Please ask for: Ms Iqraa Malik
Email: iqraa.malik@terraquest.co.uk
Telephone: 01212341390
Our Ref: M/51/20/HH
Your Ref:
Date: 17th July 2020

Application for Planning Permission for Works or Extension to a Dwelling

Development: Single storey side extension with flat roof
Location: 53 Ilex Way Middleton-On-Sea PO22 6PN

Block Plan 1:500

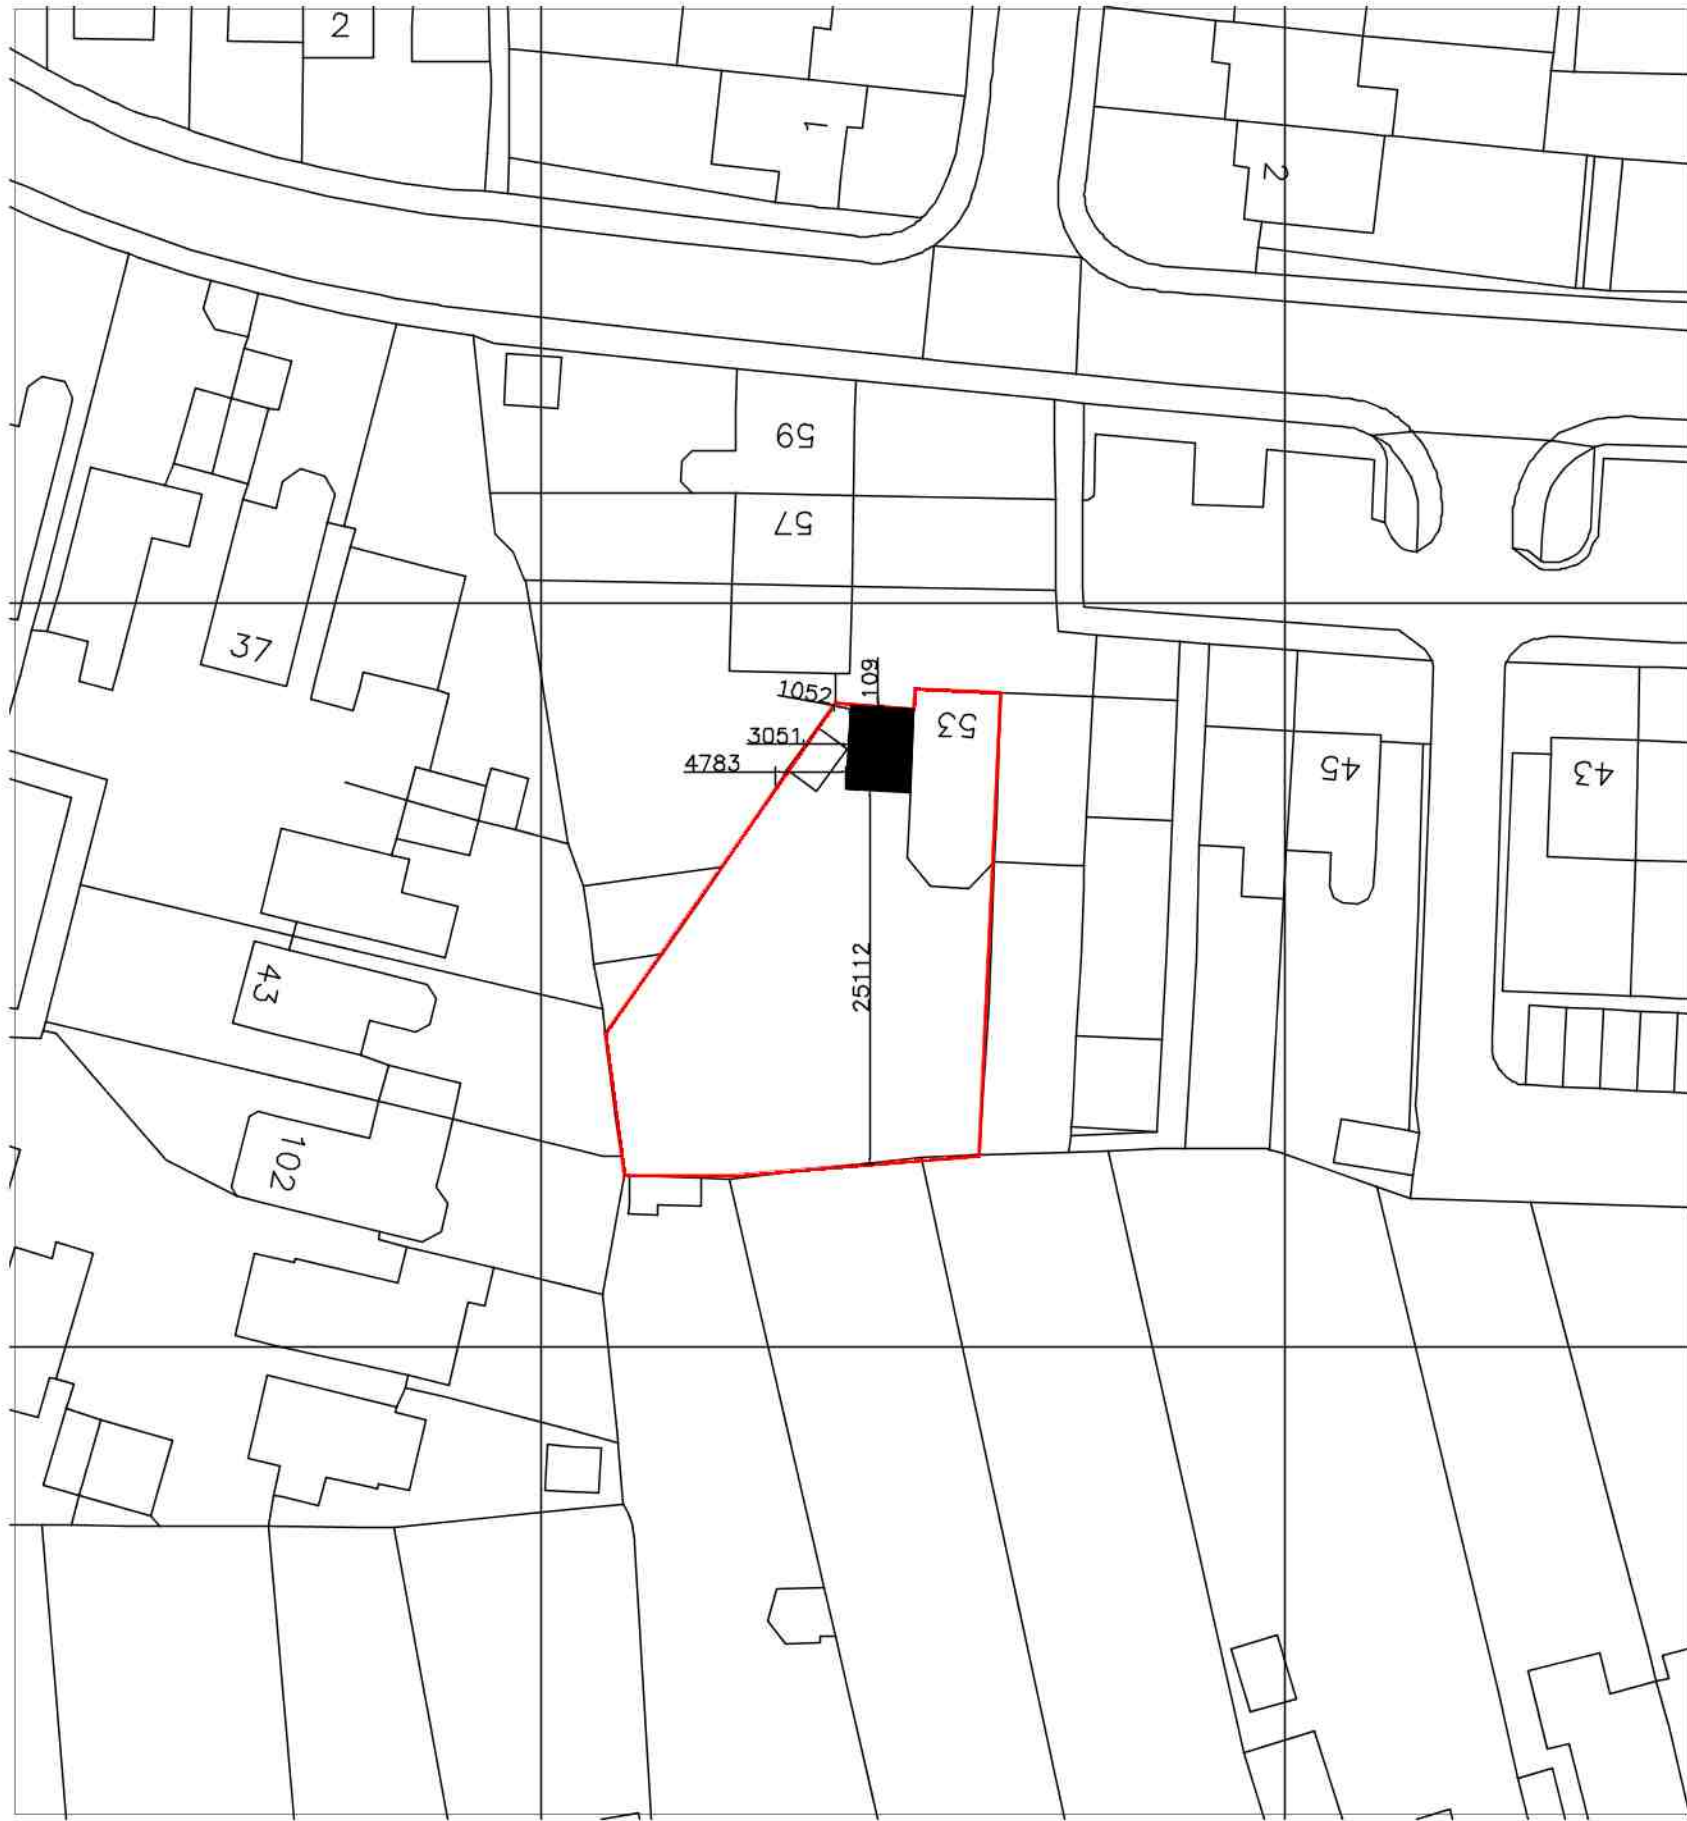
Block Plan

You are required to have dimensions from the proposed extension(s) to all site boundaries. Please amend.

All Plans

All plans require a scale bar. Please amend.
